DEVELOPMENT HEARING OFFICER

PR-2021-005745

SD-2023-00143 - PRELIMINARY PLAT (MONTAGE 5)

REQUEST: SINGLE FAMILY RESIDENTIAL LOT SUBDIVISION

MDS SKETCH
MONTAGE 5 & 6
SENSITIVE LANDS ANALYSIS EXHIBIT

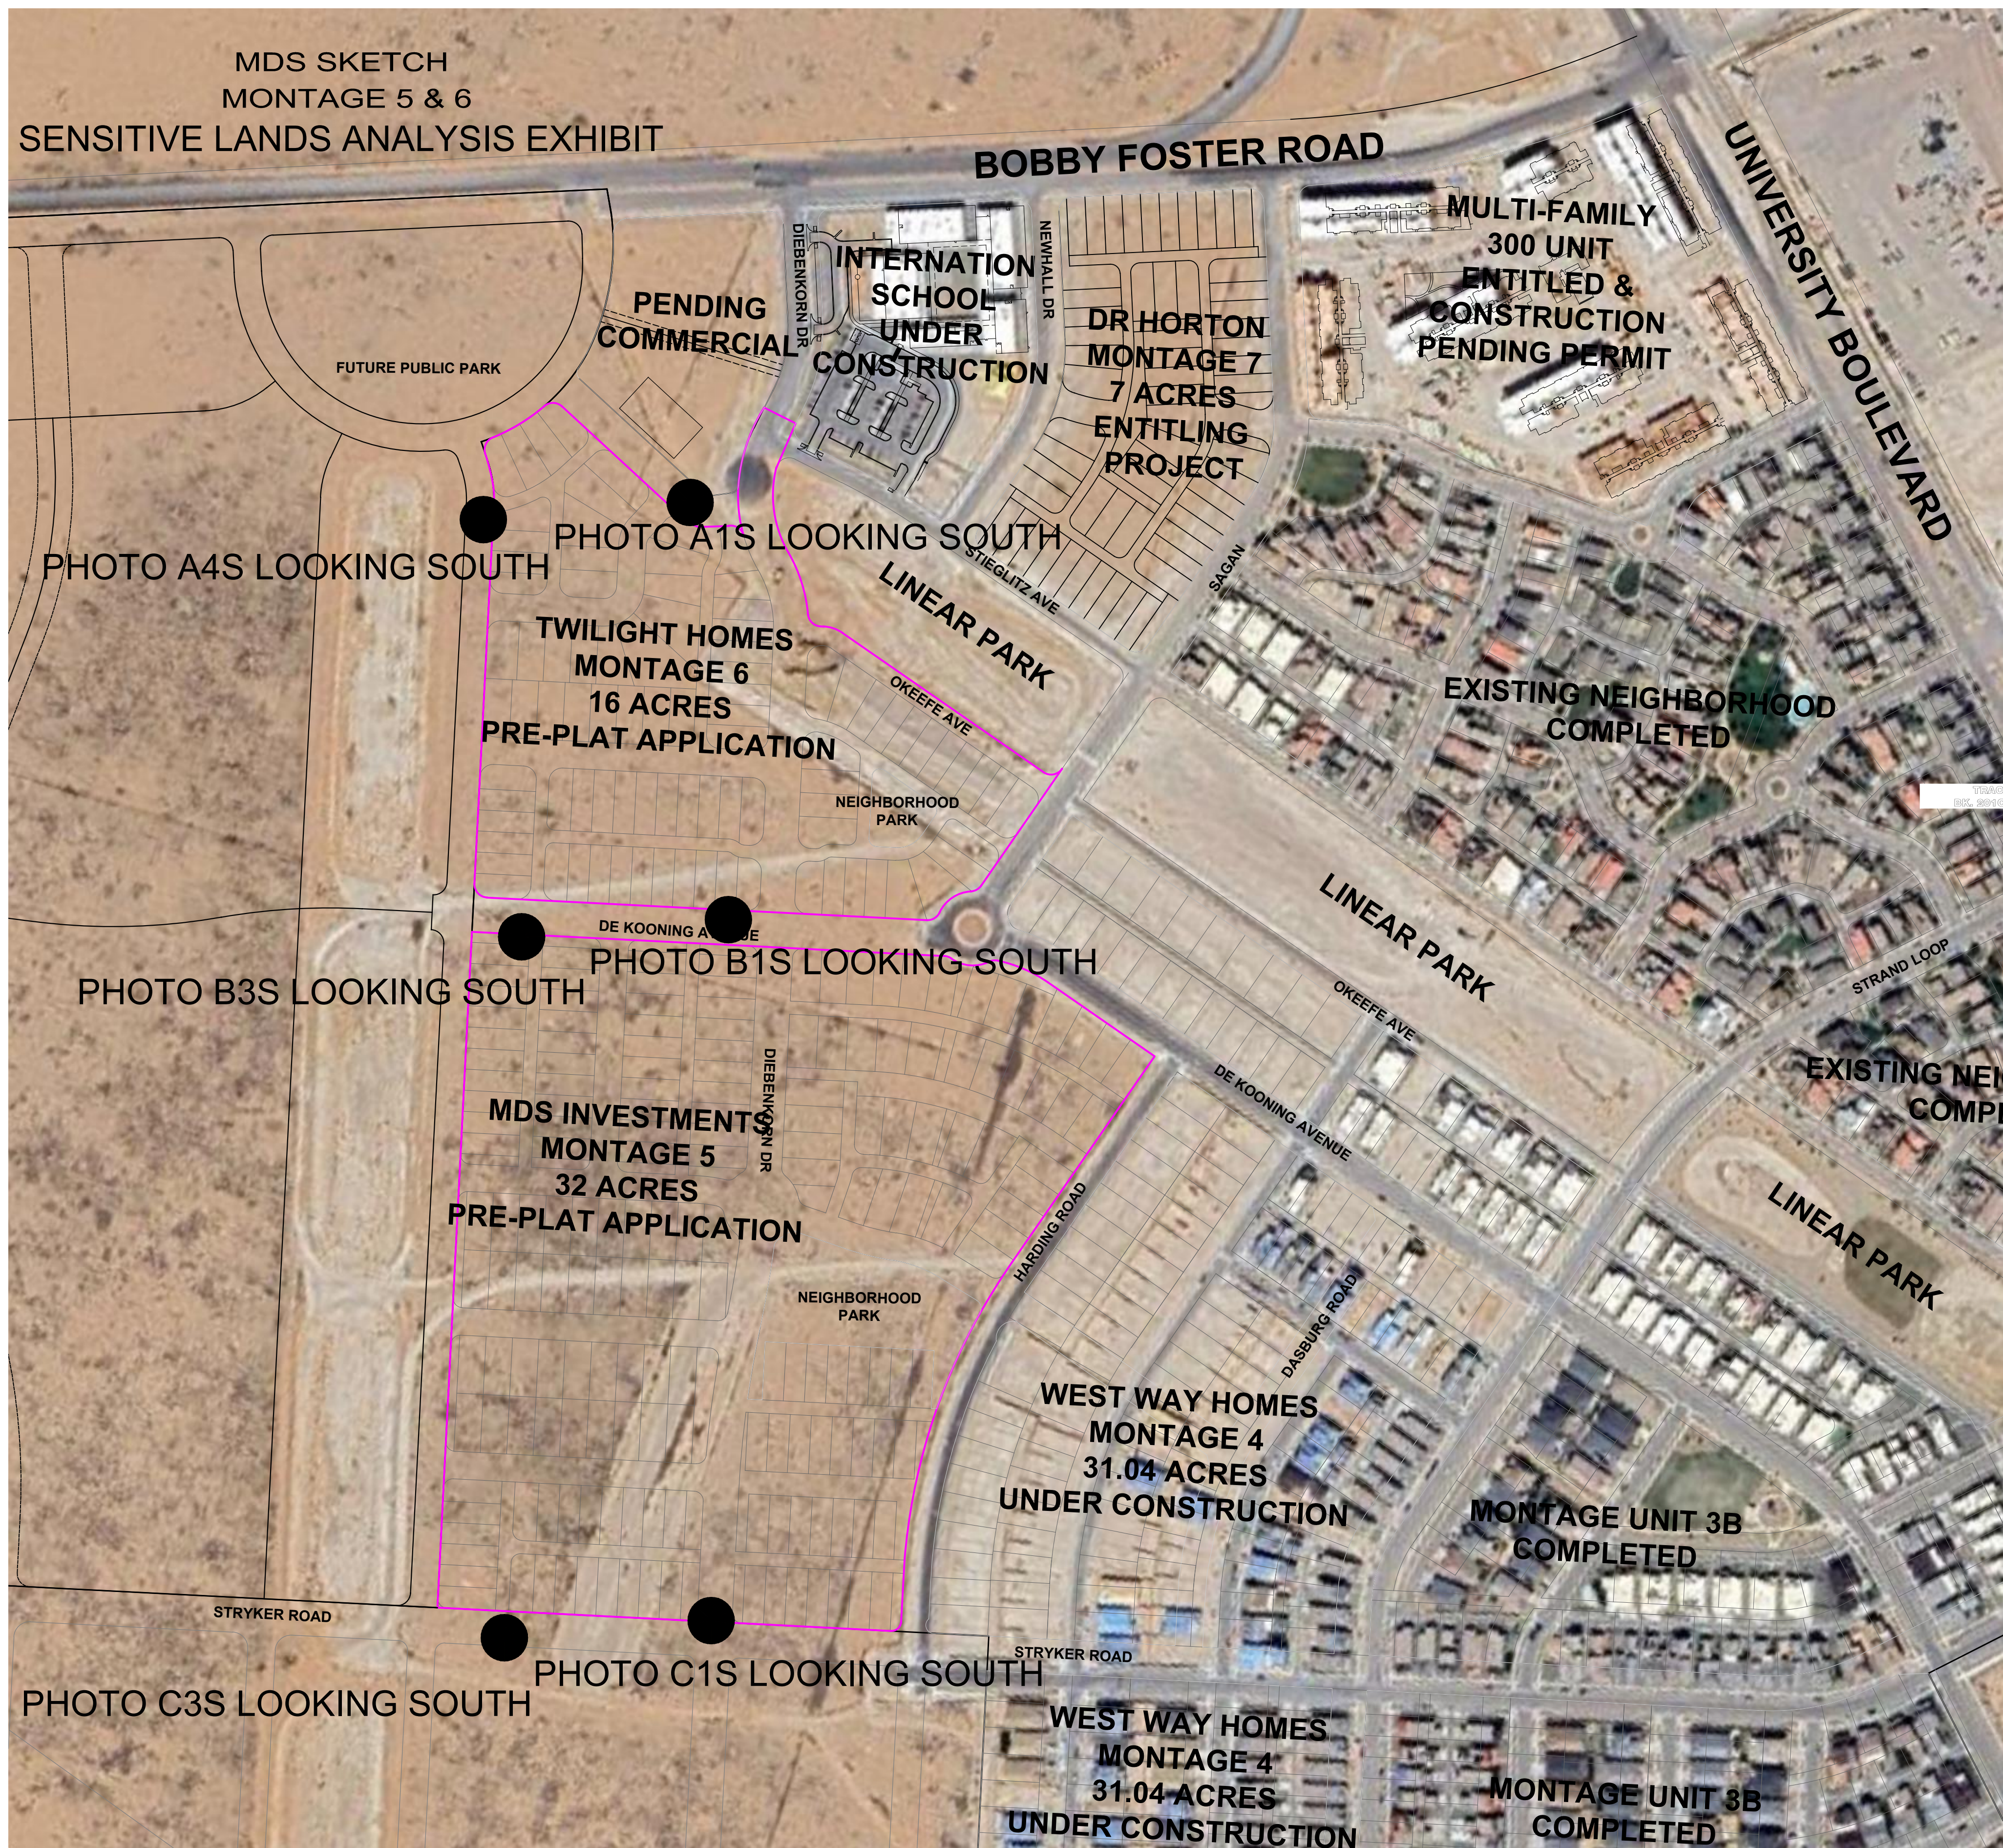
- The Preliminary Plat submittal features a required Sensitive Lands Analysis sheet submittal per Section 5-2 of the IDO, and notes that the site does not have any sensitive land features. However, no analysis is provided in the sheet per 5-2(C)(2). **The Applicant should submit a duplicate of the Sensitive Analysis submitted for application PR-2020-4138.** See this link for guidance on the requirements. [Sensitive_lands_analysis_form \(cabq.gov\)](https://documents.cabq.gov/planning/development-facilitation-team/DFT_Application.pdf)
